Determination of Thomas Street Car Park Site Modification 6

The above modification application lodged by Meriton Property Services Pty Ltd (the proponent) has been referred to the Planning Assessment Commission (the Commission) for determination under Ministerial delegation dated 14 September 2011. The delegation is authorised because more than 25 submissions in the nature of objections were received.

COMPARABLE
HEIGHT STUDY
A-0201
SECTION 75W MODIFICATION 6

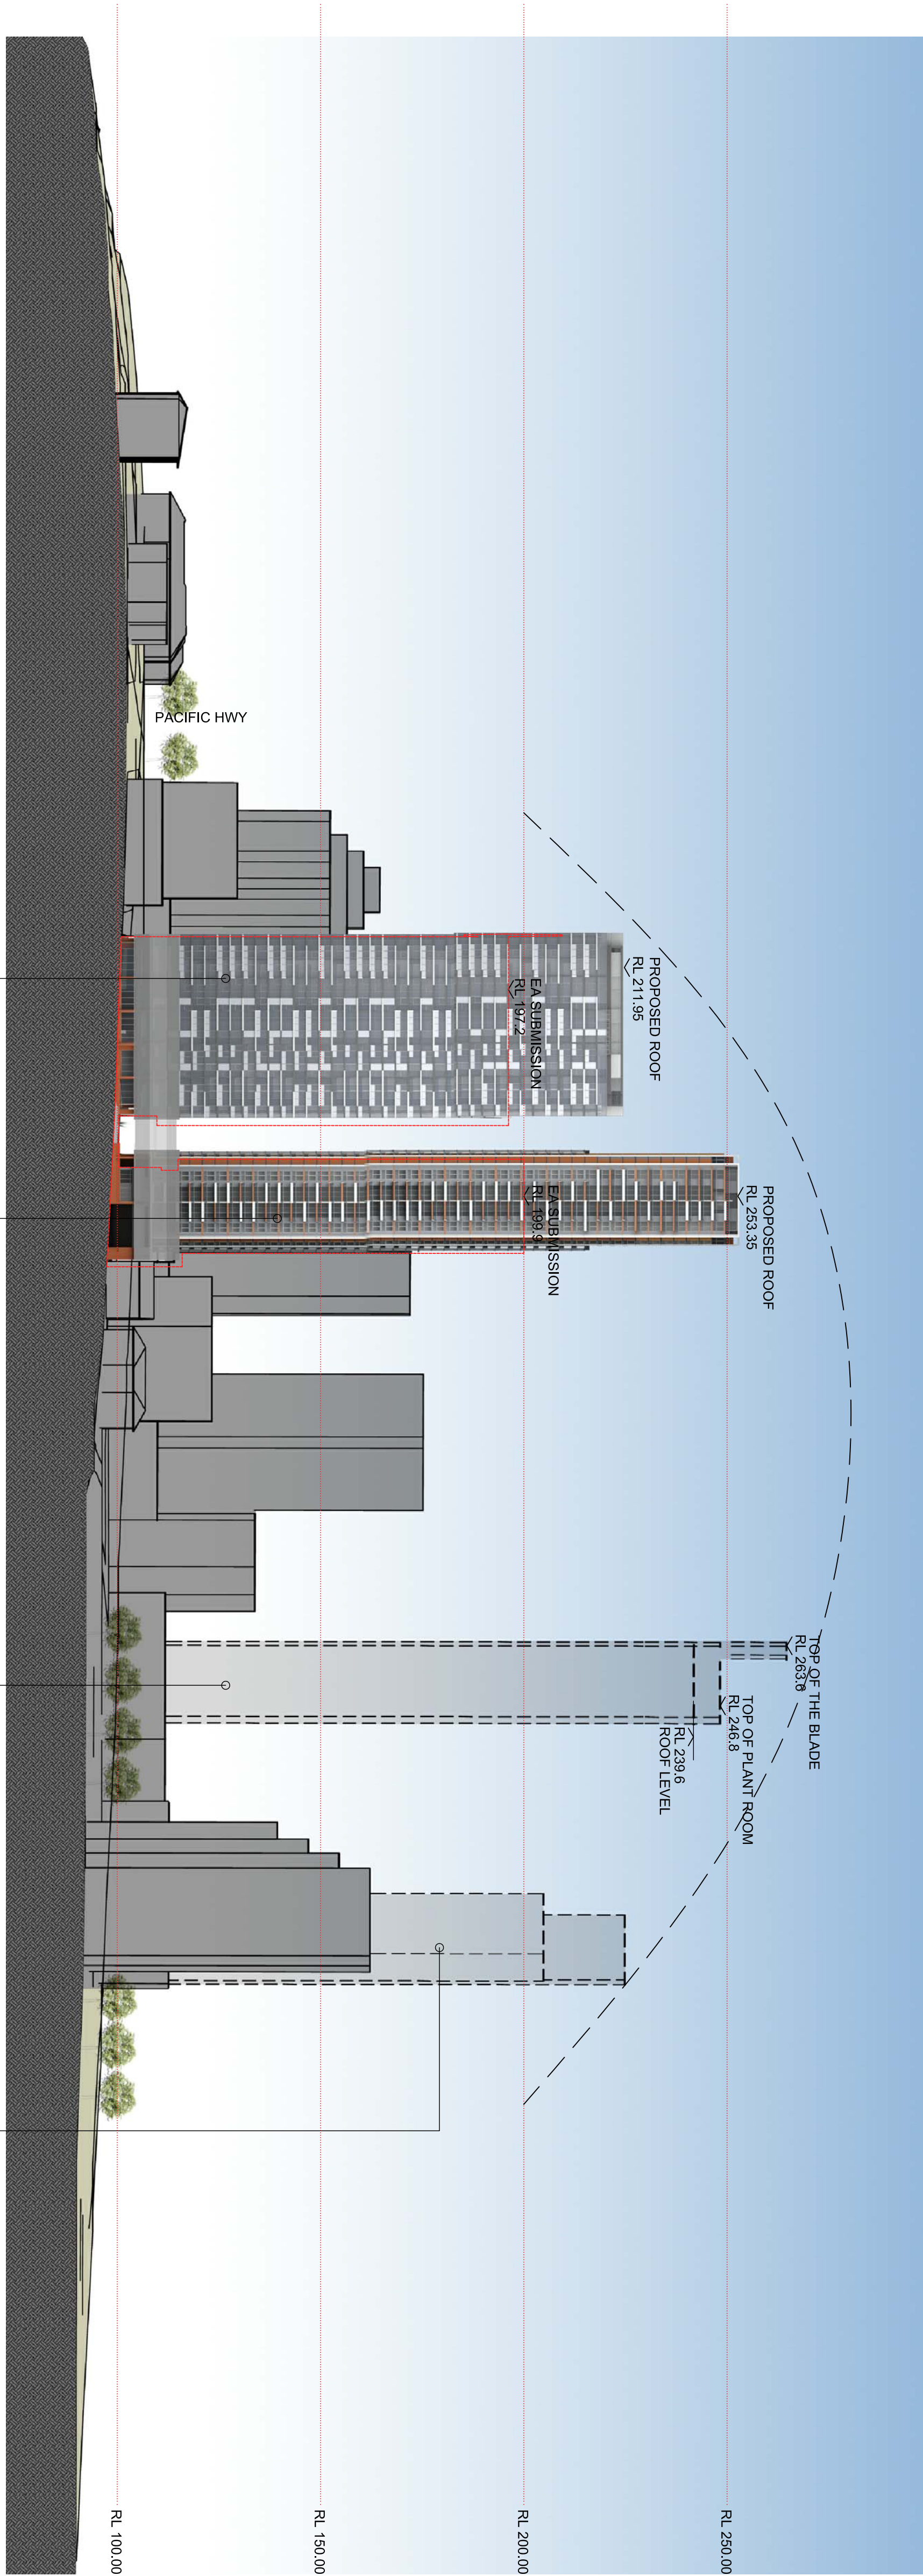
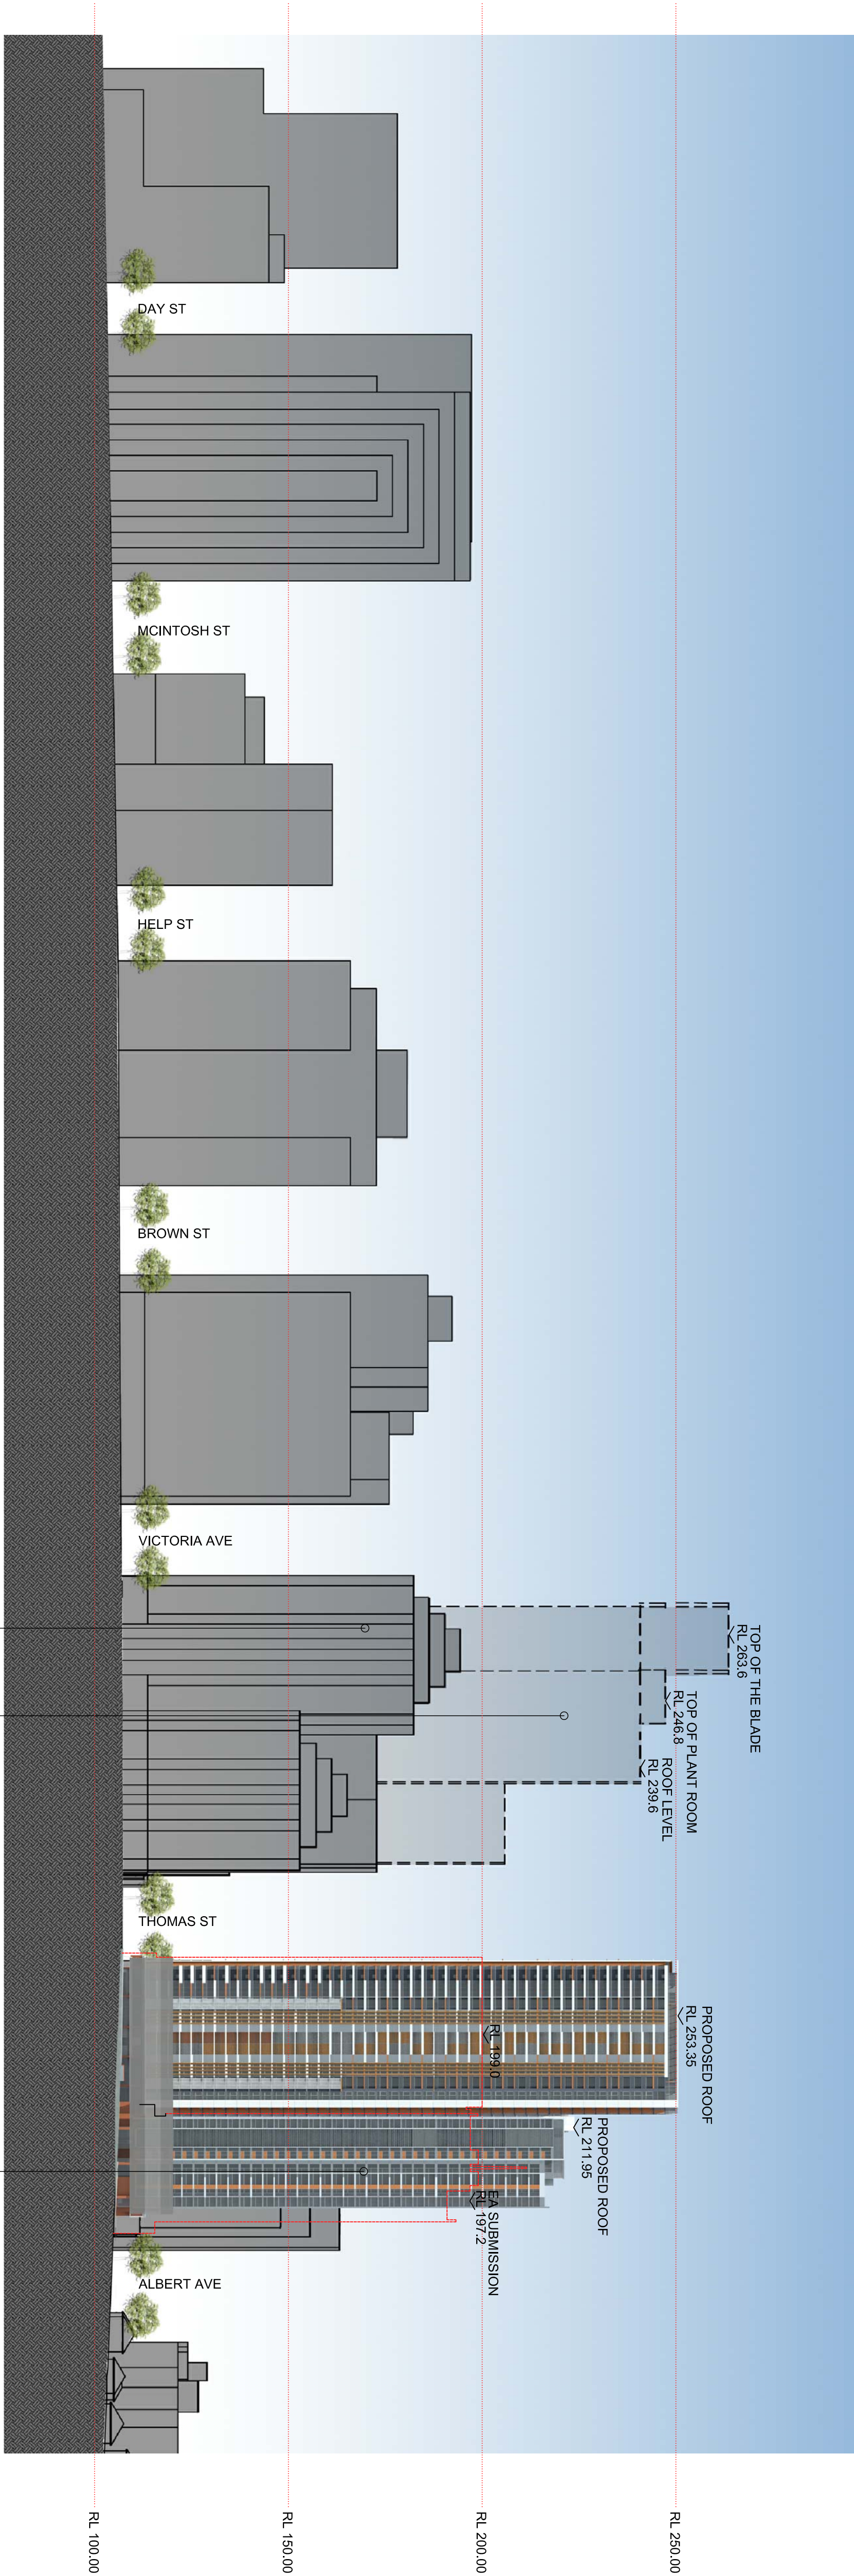
The assessment report considered the proposed 47 storey height (building 1) excessive in the Chatswood CBD context. It recommended the height be reduced by 5 storeys.

In this case, the Commission concludes that the proposed extra height is inconsistent with the general planning principles for the CBD and with the strategic direction for development of the CBD as set out in the LEP.
